The Coal
Authority

Re: Planning application 2023/62/93704/E

**Erection of 10 dwellings and associated works at Land Northwest of Urban Terrace,
Denby Lane, Grange Moor, Huddersfield, WF4 4EB**

1 Proposed Site Layout

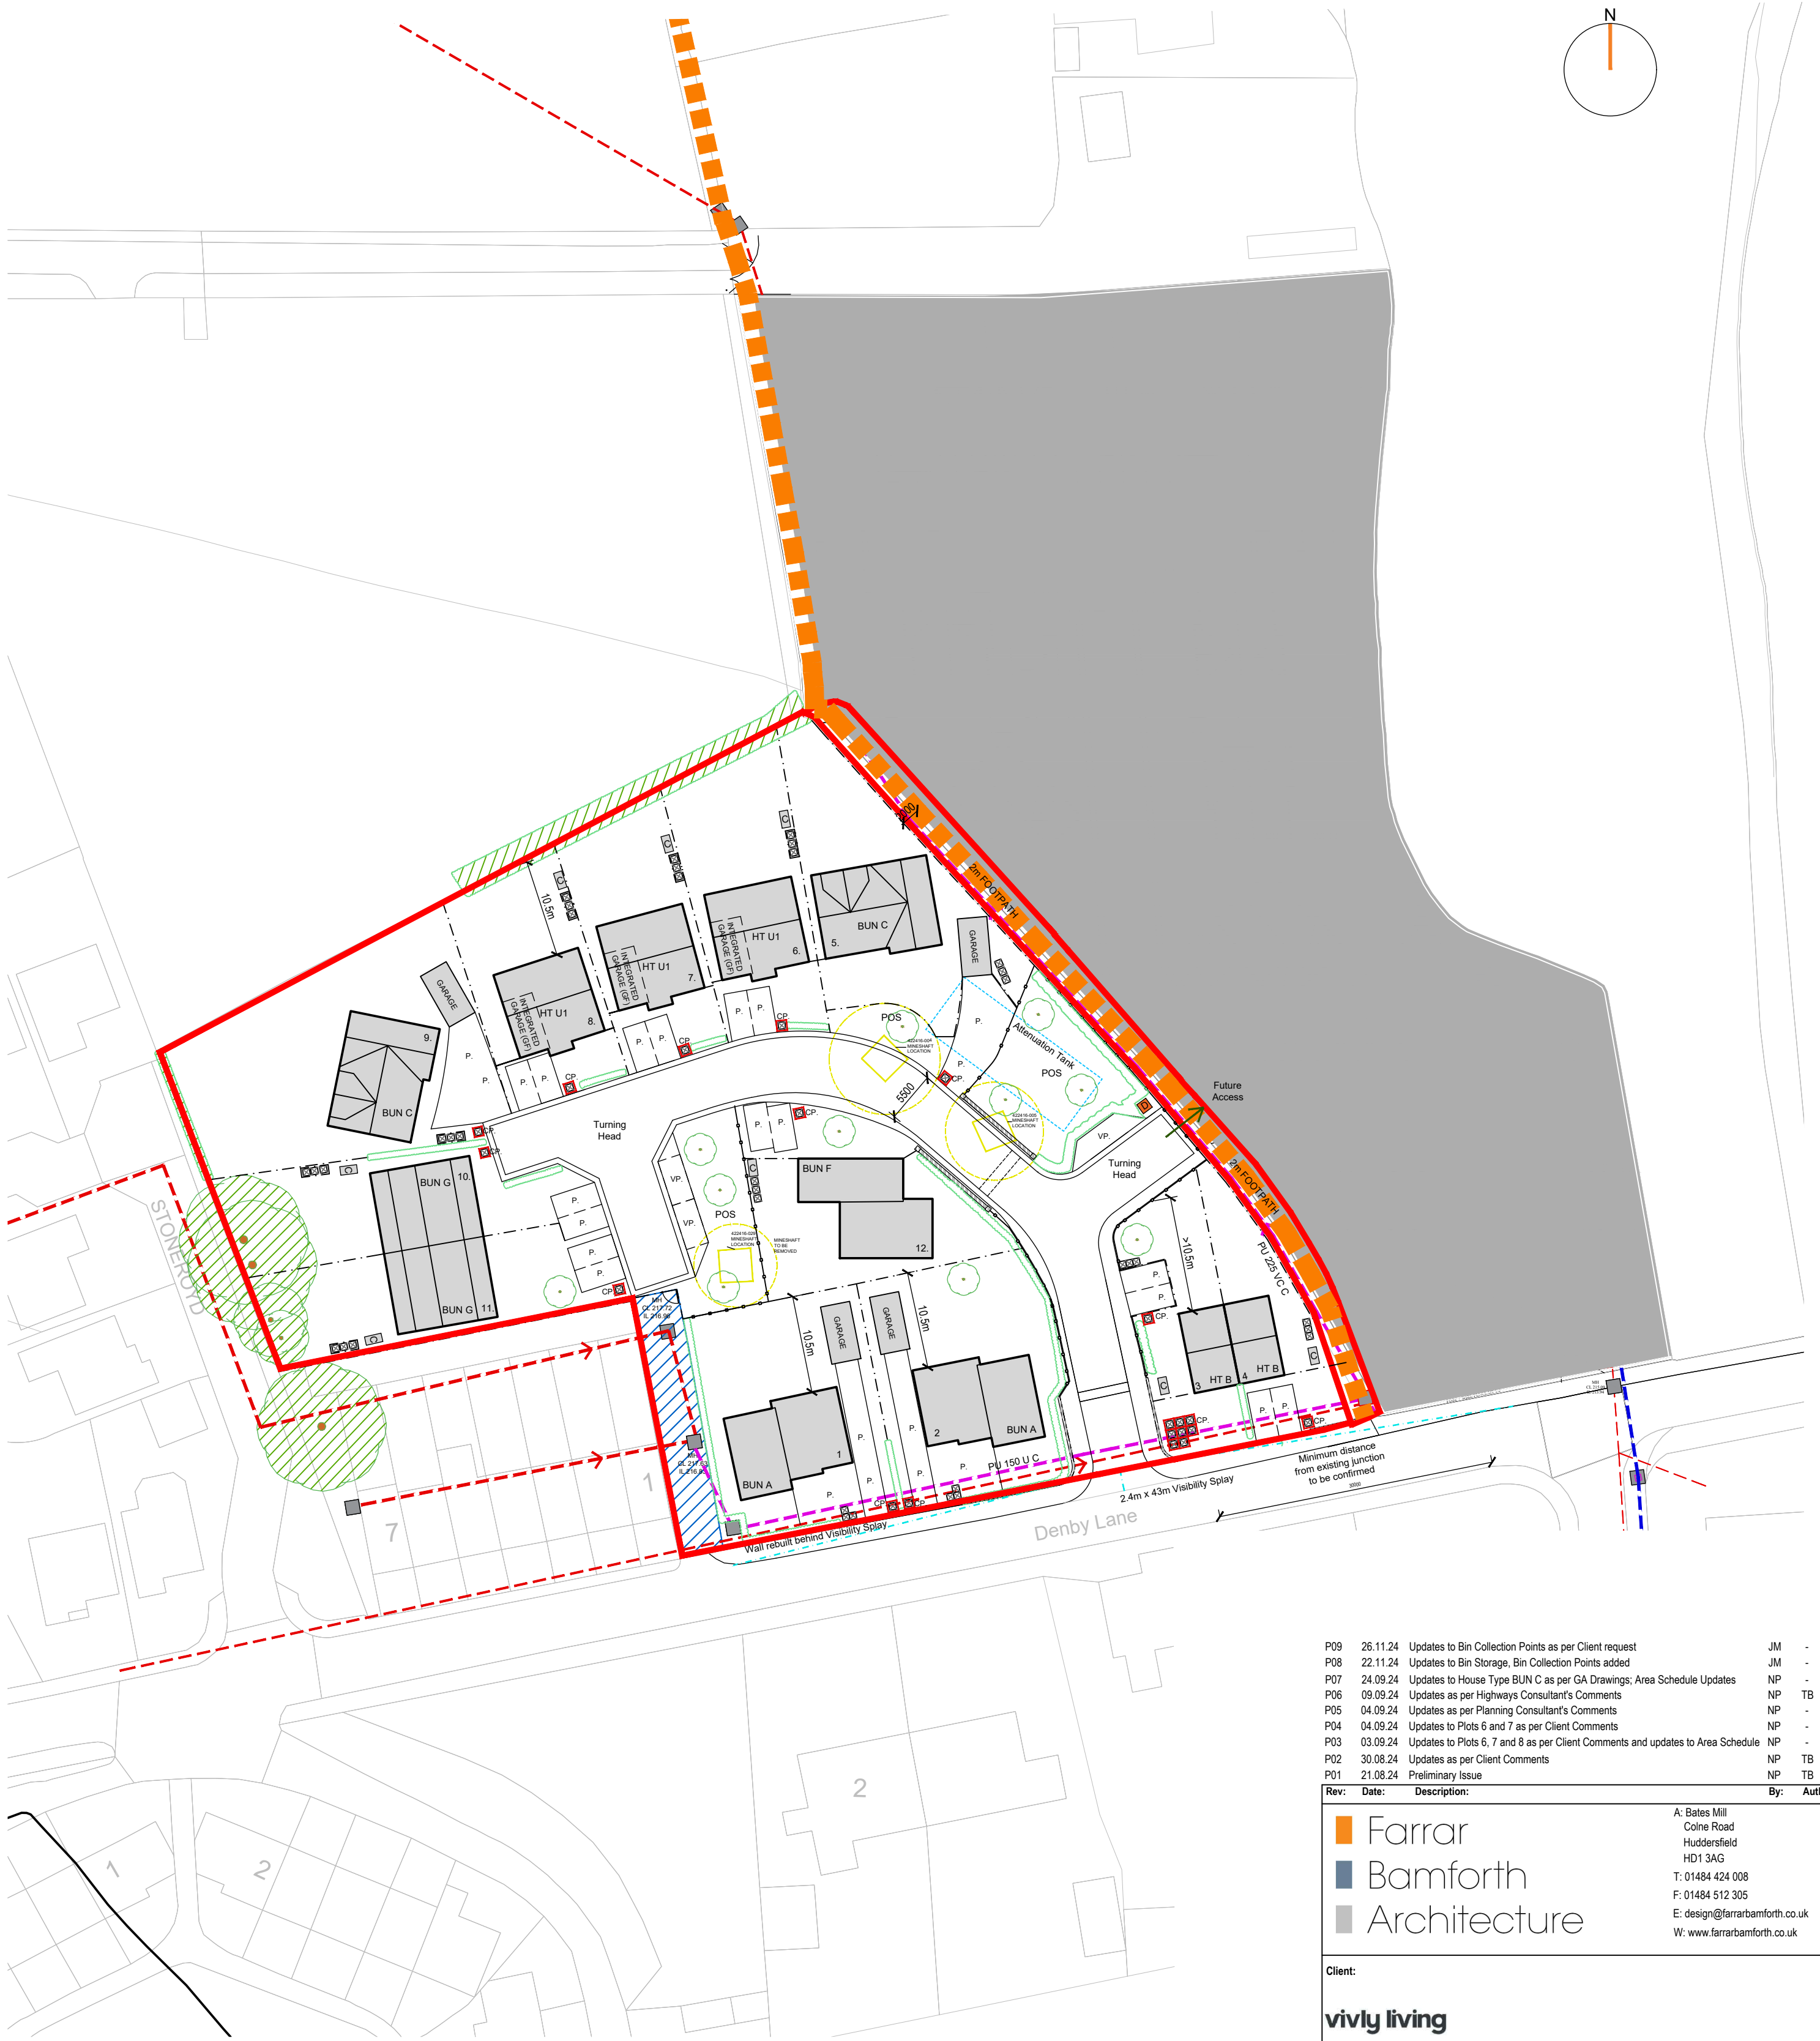
We are pleased to note that the shaft positions and their calculated zones of influence are shown on the proposed Site Layout (Drawing No 22D26-FBA-ZZ-XX-DR-A-0708 Rev. P11). This plan demonstrates that the proposed dwellings have been sited in a manner which avoids the shafts and their associated zones of influence.
